Application No: CM/70/21/PL
Site Address: Land at Wren Cottage Horsemere Green Lane Climping BN17 5QZ
Description of works: Subdivision of the plot and construction of 3 detached bungalows with associated parking, access and landscaping (resubmission of CM/17/21/PL). This application is in CIL Zone 3 and is CIL Liable as new dwellings.

Thank you for your internet representation made on 13th December 2021 which has been recorded as an objection with the comments as follows:

Title
Location & Block Plan

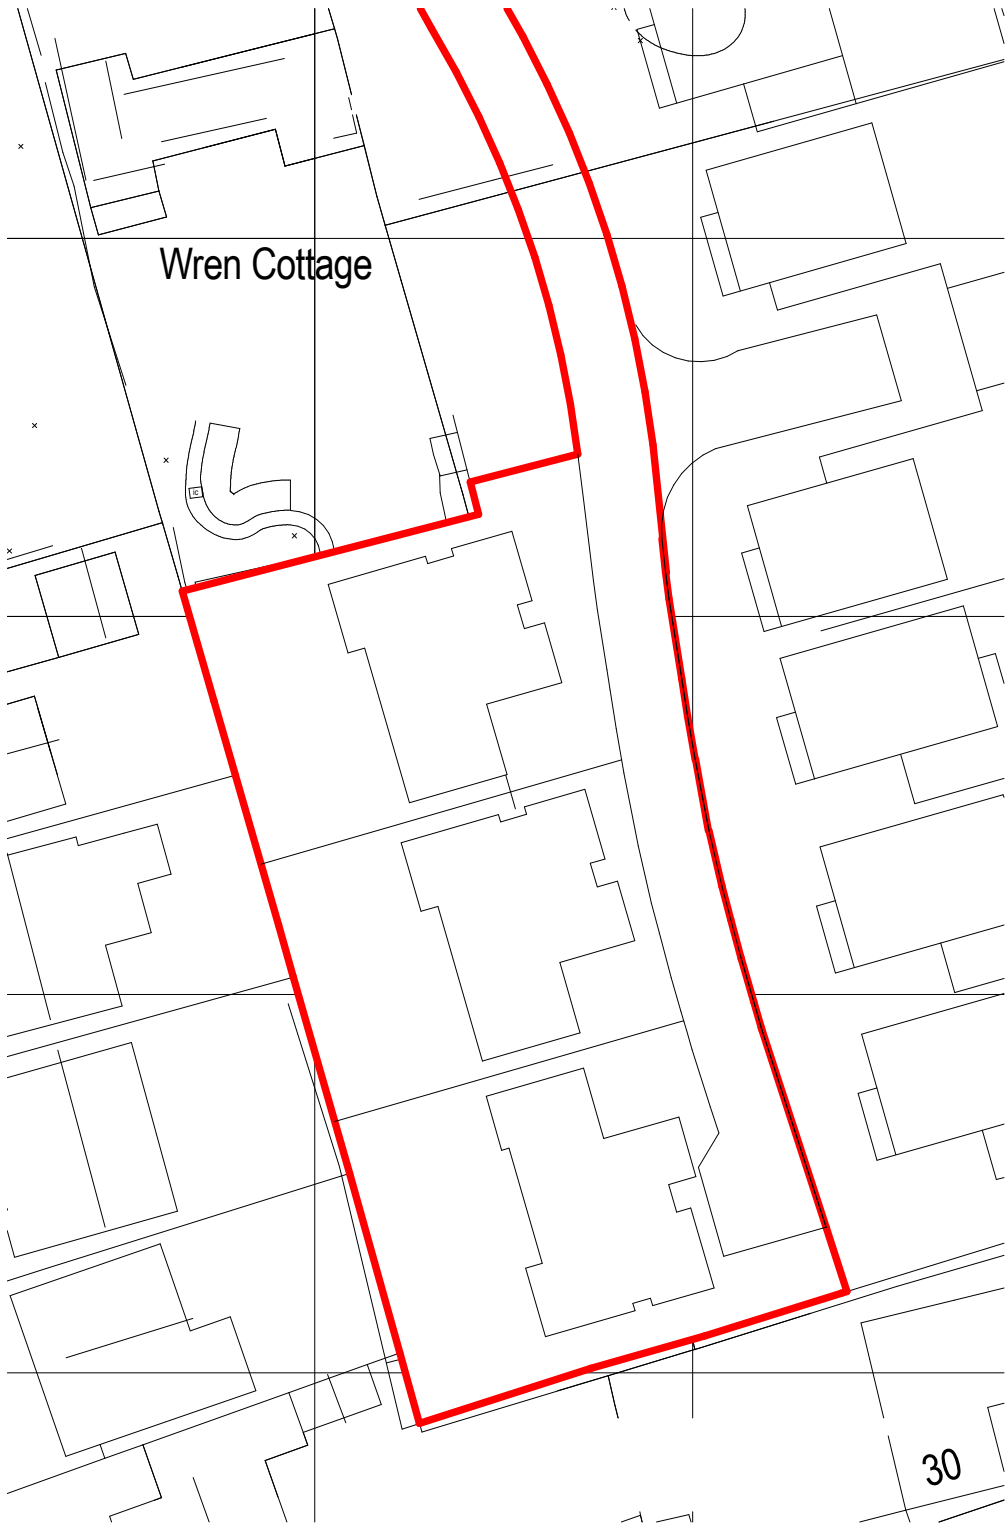
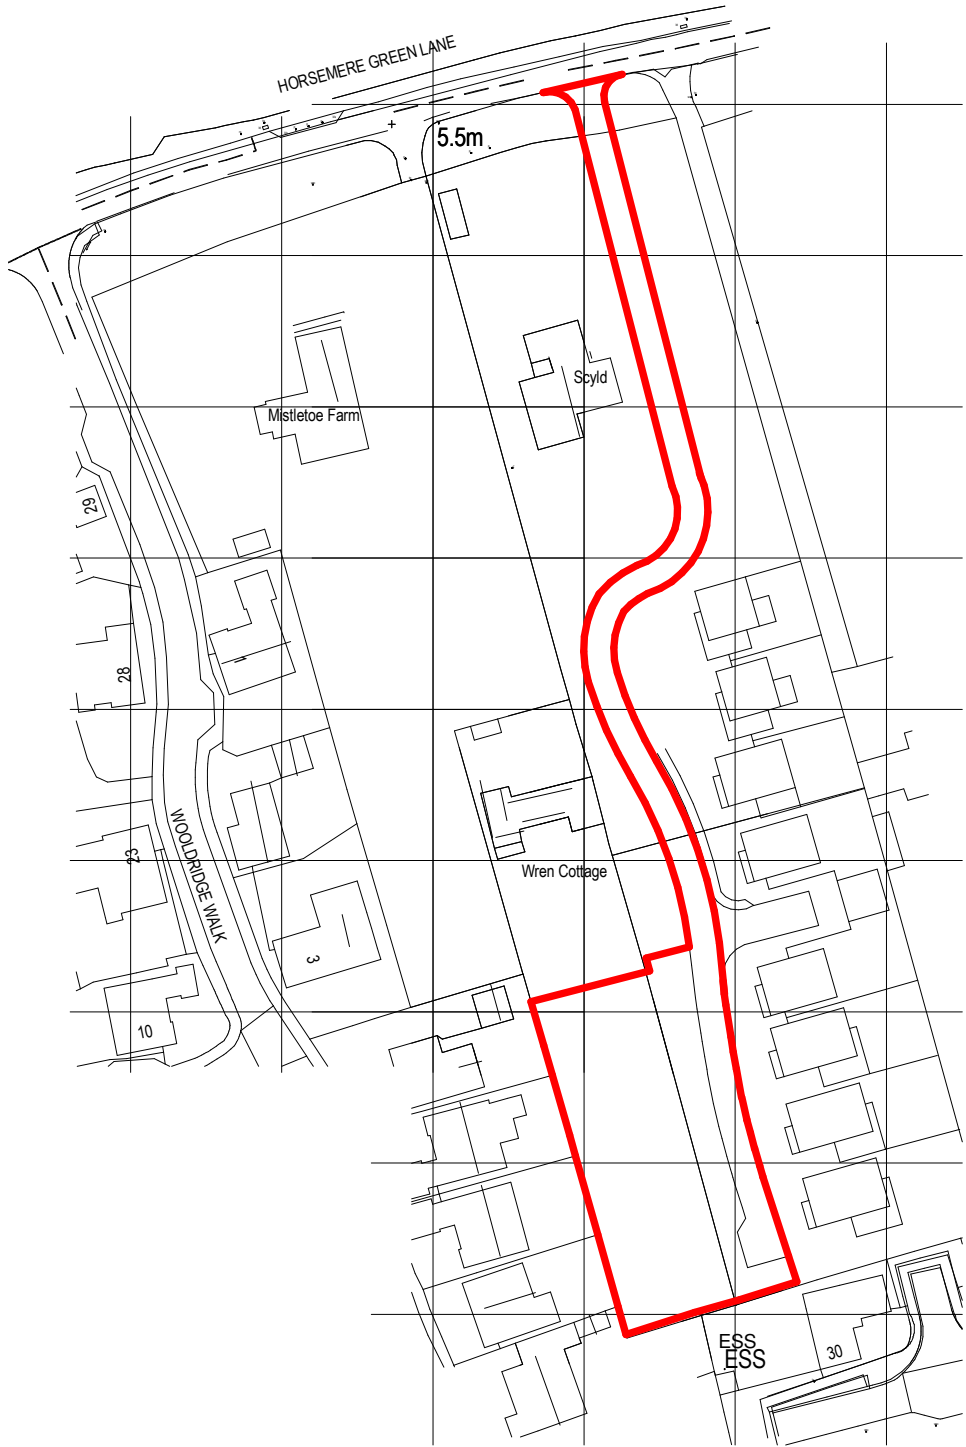
1. Proximity to existing properties in Wooldridge Walk. Plot 1 is within 20 metres of No.4 Wooldridge Walk and within 16 metres of No.5. Plot 2 is within 17 metres of No.5 Wooldridge Walk. Plot 3 is within 19 metres of No.7. I am reliably informed that a distance of approximately 21 metres is considered to be the minimum for planning purposes.

7. There is insufficient visitor parking. There is no turning point at the end of the access road to accommodate

visiting vehicles, especially delivery vans and lorries and refuse collection vehicles.
